**Oakdale West Estate Modification 5 (SSD-7348-Mod-5)
Request for Additional Information**

I refer to the Department's assessment of the Oakdale West Estate Modification 5 (SSD-7348-Mod-5). After careful consideration, the Department is requesting you provide additional information, including:

PROPOSED INDUSTRIAL FACILITIES
PRECINCT 1
OAKDALE WEST
Estate Road HORSLEY PARK, NSW 2175
MOD 5

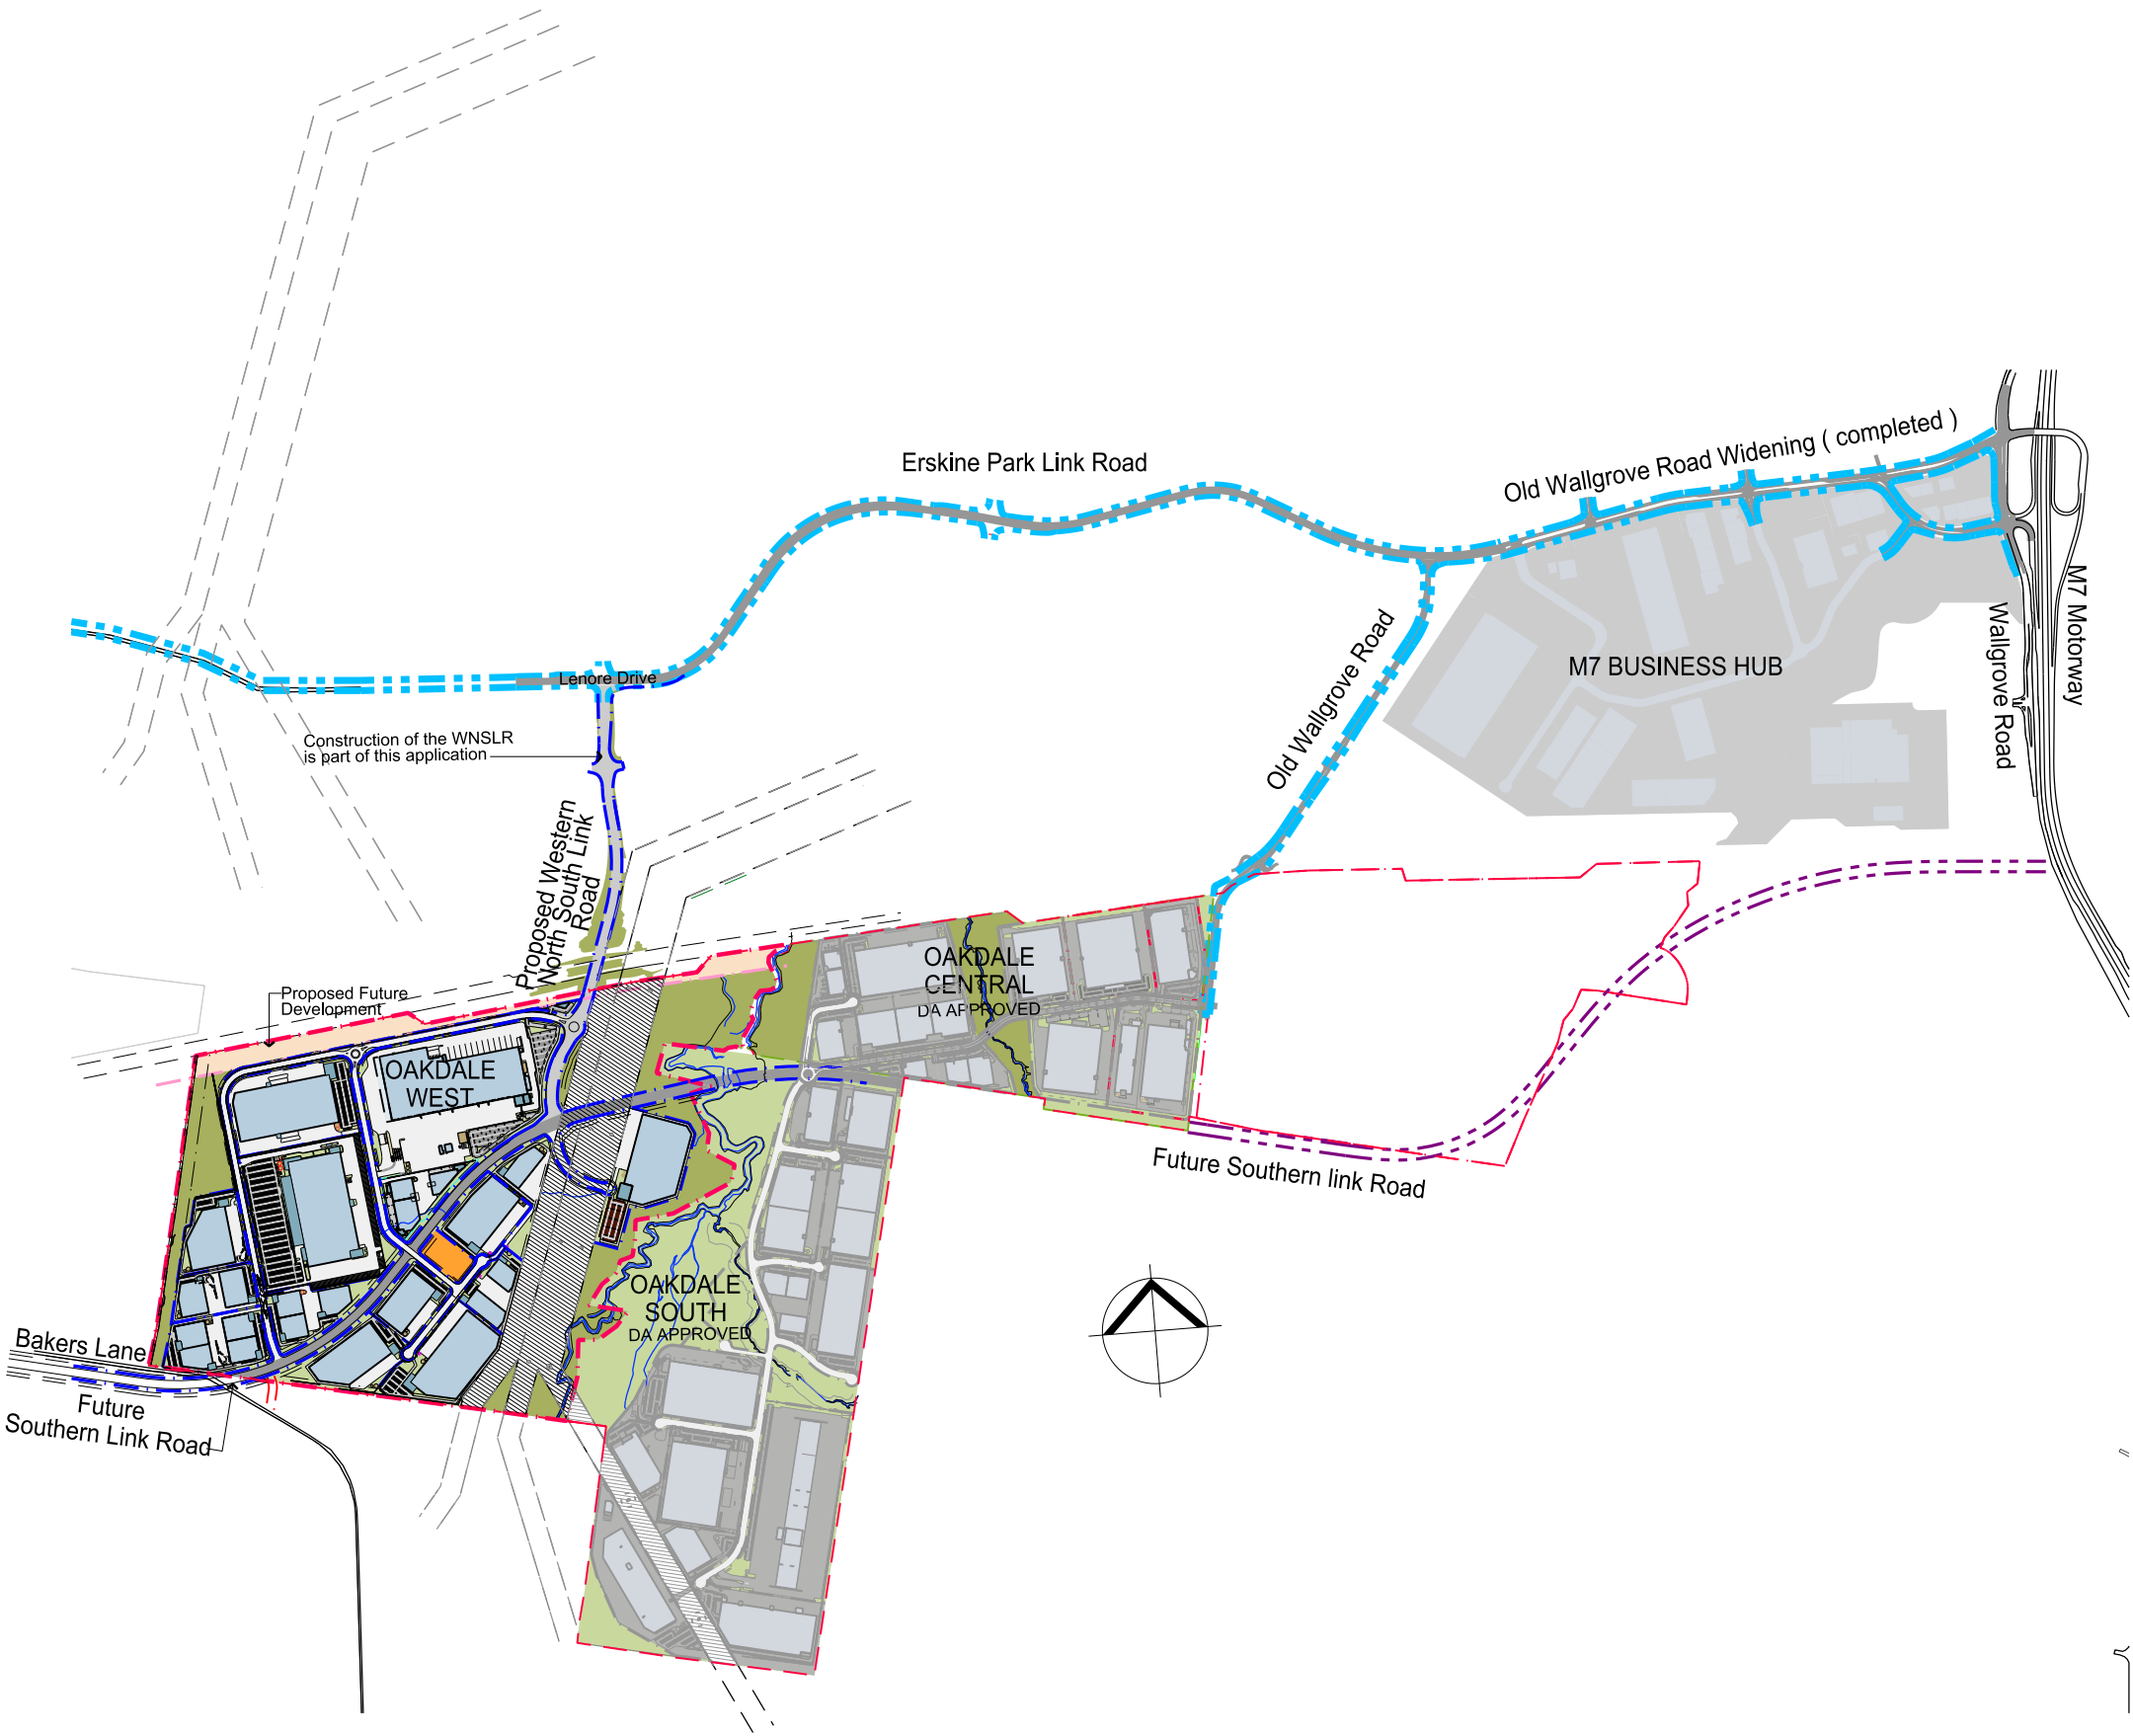
- an amended Oakdale West Estate Concept Plan (for the entire estate, not just Precinct 1) showing the revised landscape and building setbacks for all lots fronting the Southern Link Road (SLR) per the attached SLR Blue Option Overlay Plan
- clarifying the implications on the layout of Lots 1, 1B and 1C if the proposed 7 m landscape and 17 m building setbacks are retained but measured from the red line shown on the attached SLR Blue Option Overlay Plan (i.e. if the land between purple and red lines forms part of the SLR and the actual road reserve boundary is the red line)
- please respond to issues raised in the TfNSW letter dated 27 September 2020, including the concerns raised in relation to the location of buildings and structures (including utilities).
